**Addendum No. 1**

RE: Contract ID C202606

**Brunswick County (BK-5129)**

Replace Fender System Bridge #14 on NC-133 Over Atlantic Intracoastal Waterway  
Between Southport and Oak Island

REVISIONS						SHEET NO.
NO.	BY:	DATE:	NO.	BY:	DATE:	S-1
1			3			TOTAL SHEETS 6
2			4

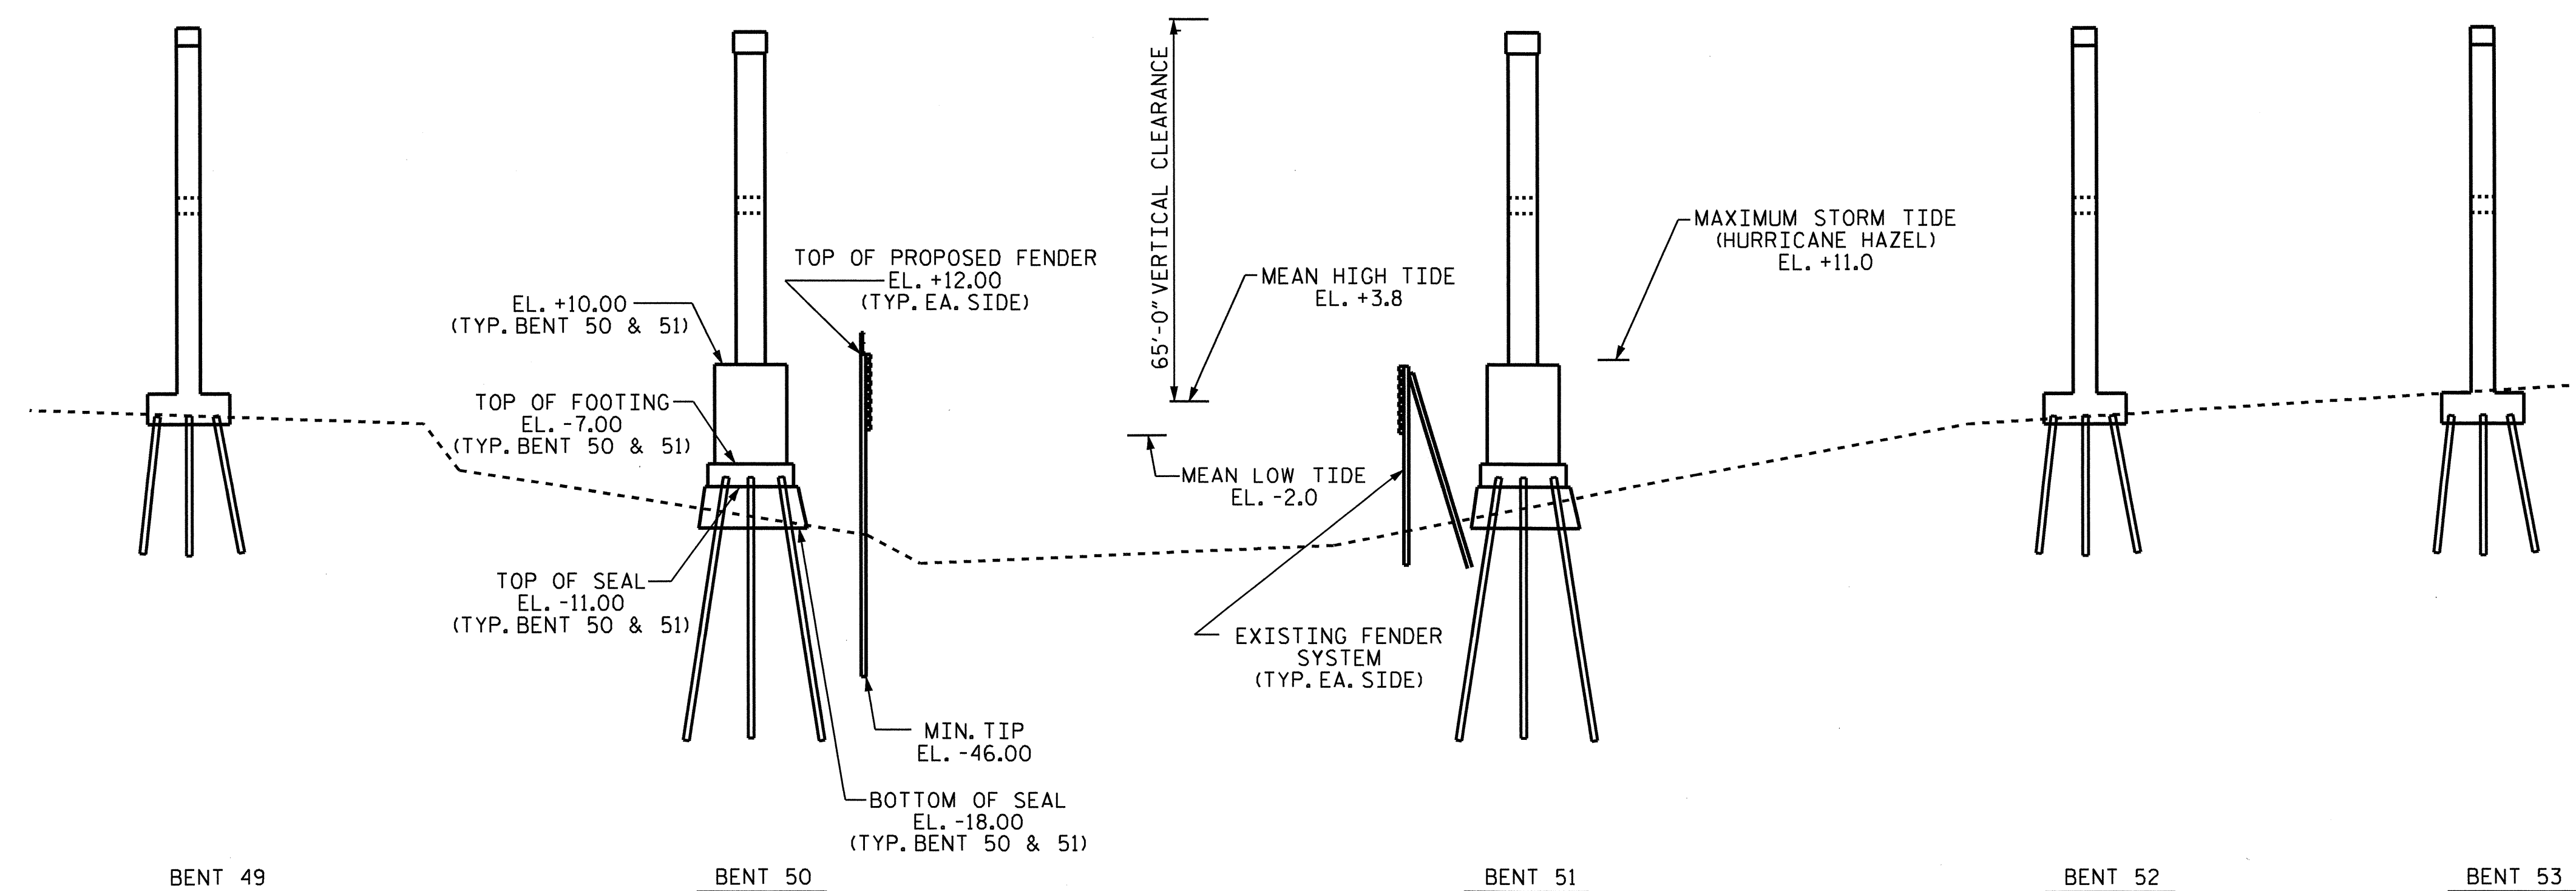
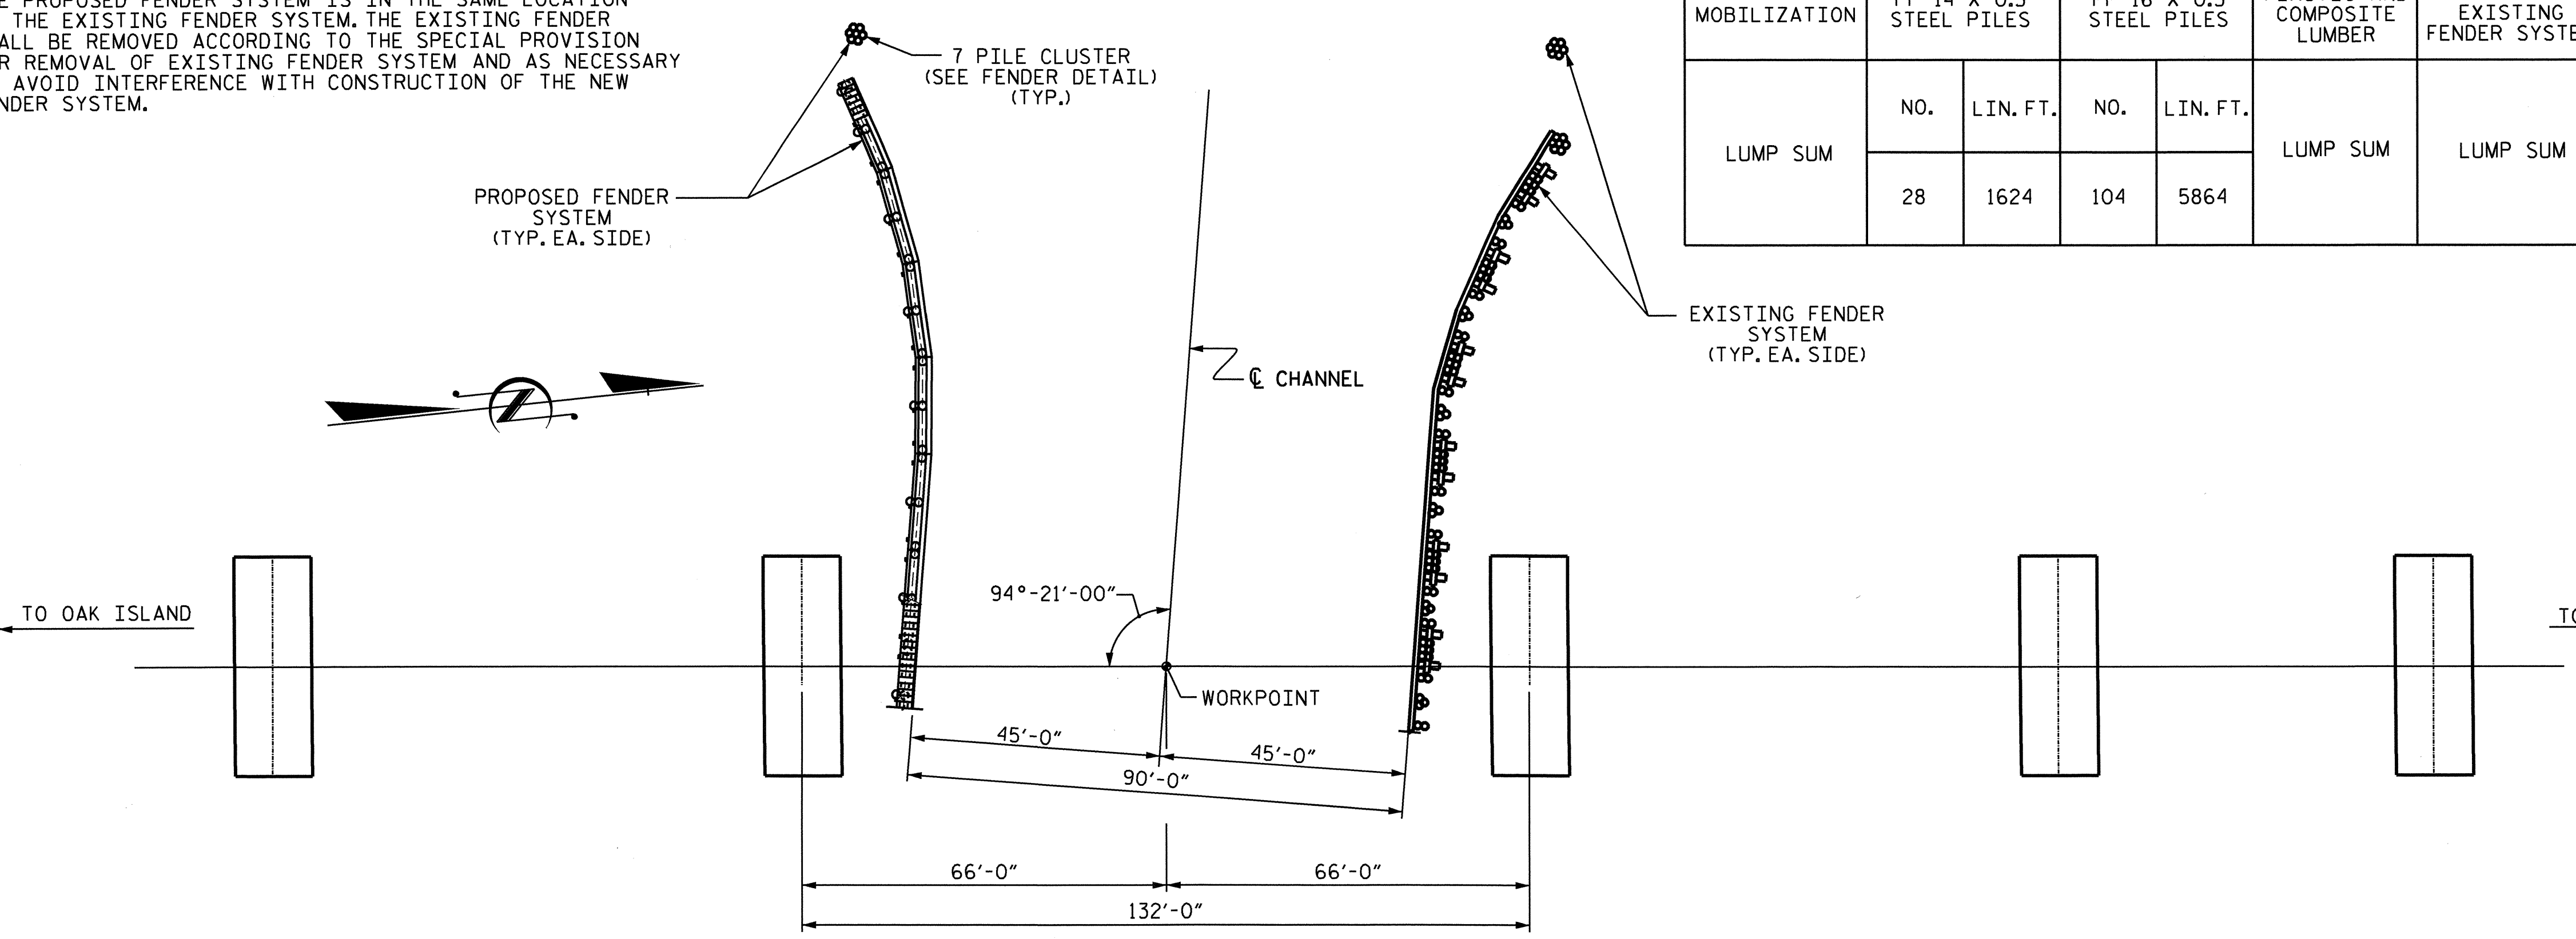
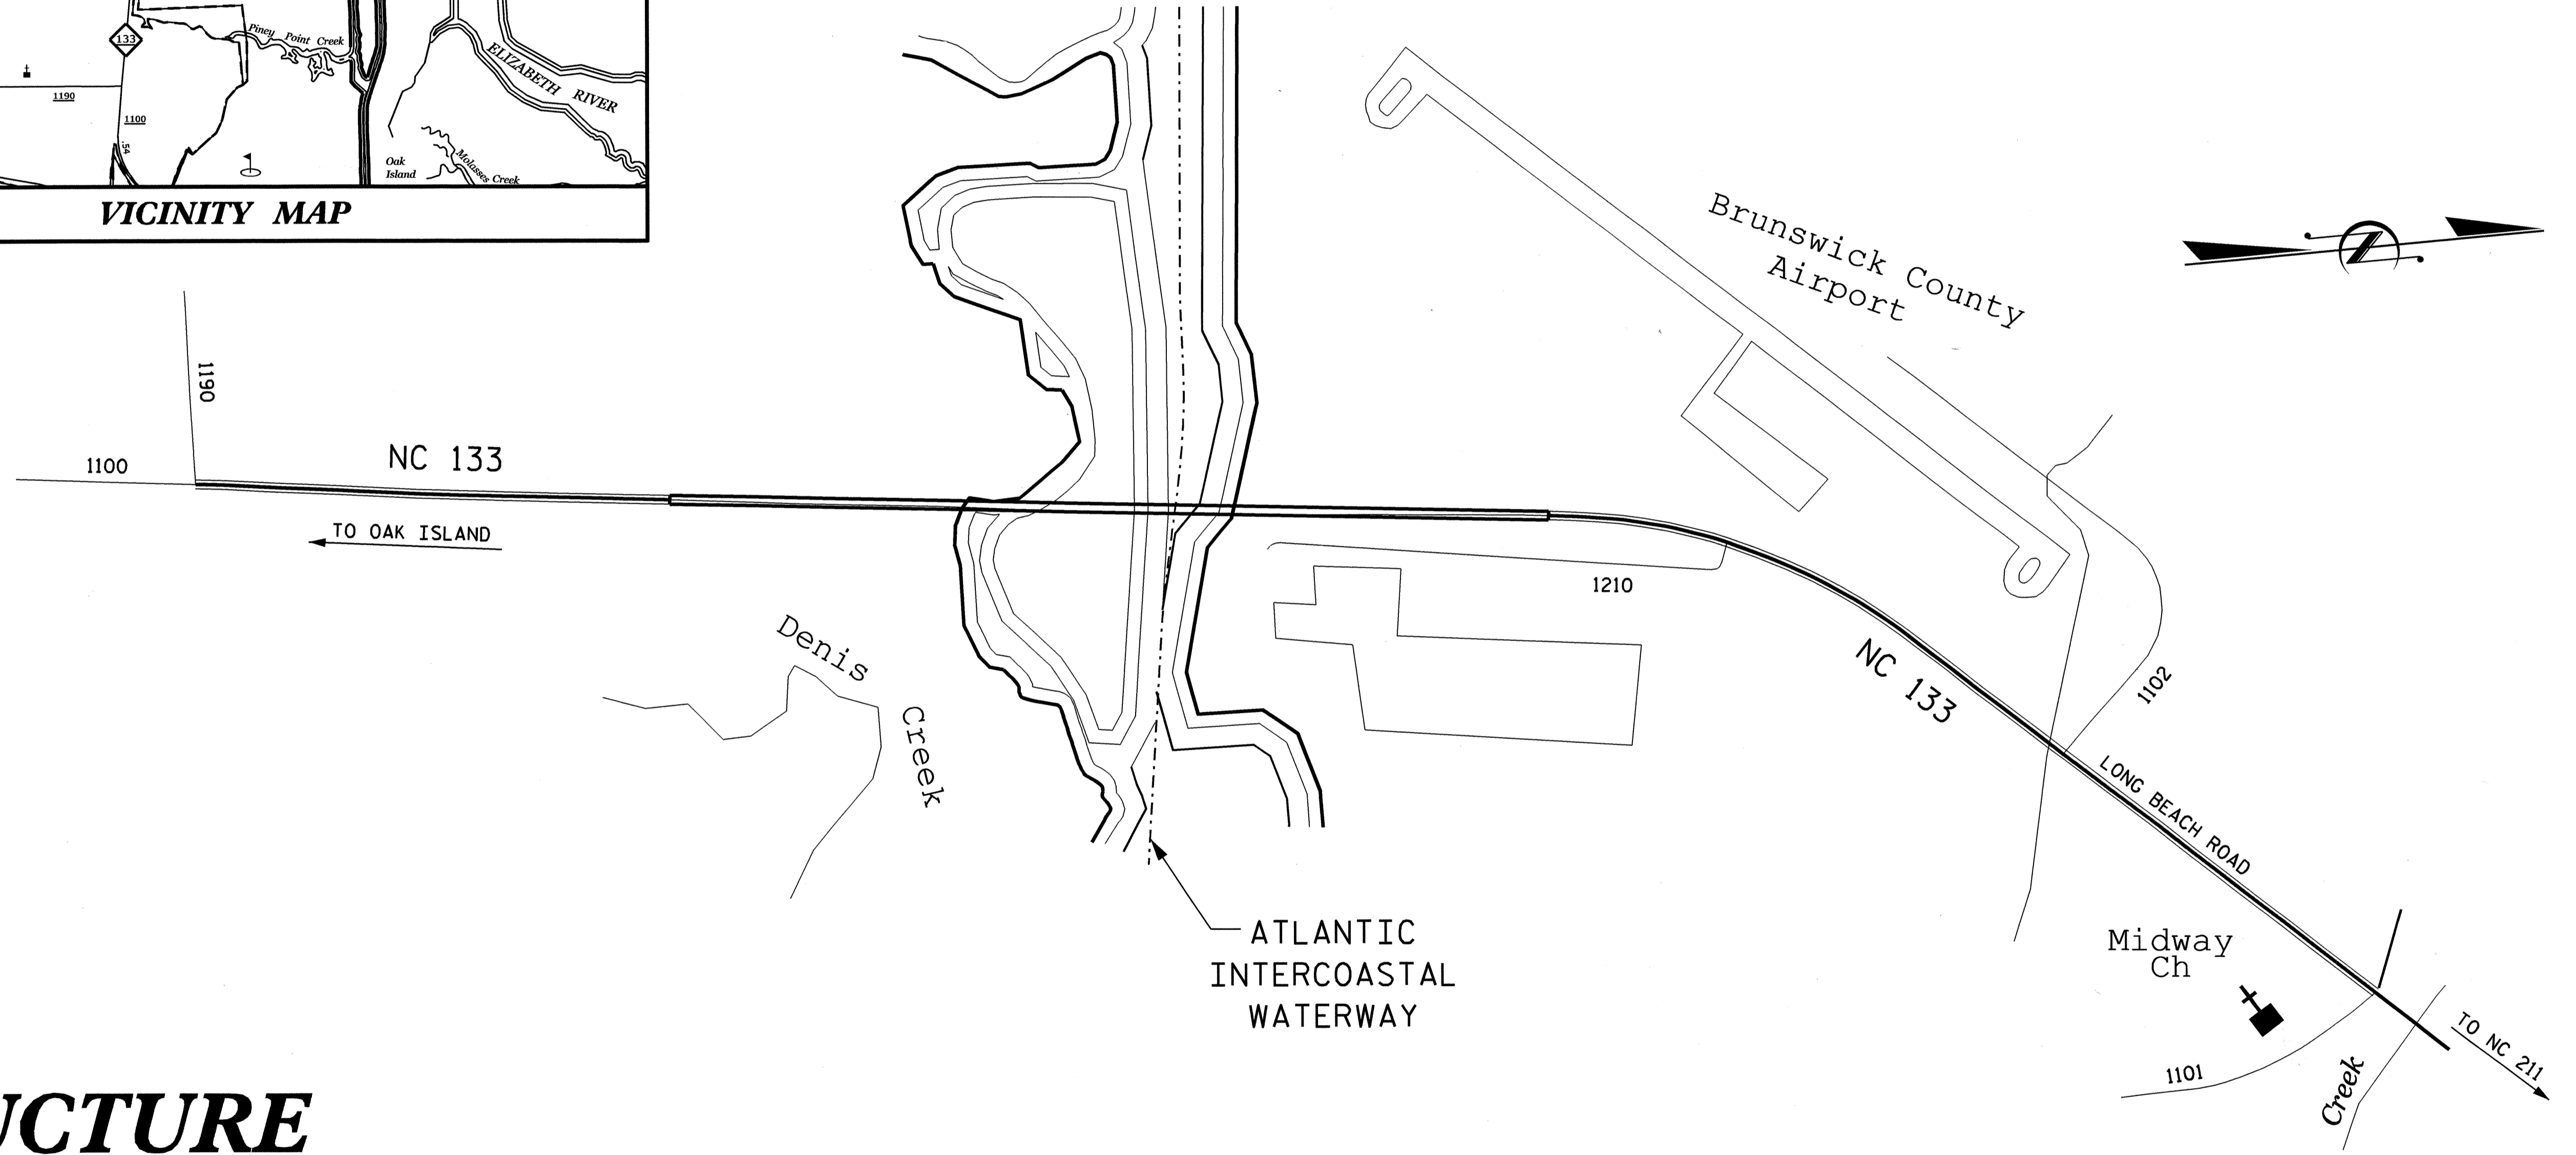
On Sheet S-1 the note concerning the "Stainless Steel Bolts" has been revised. Please void Sheet No. S-1 in your plans and staple the revised Sheet No. S-1 thereto.
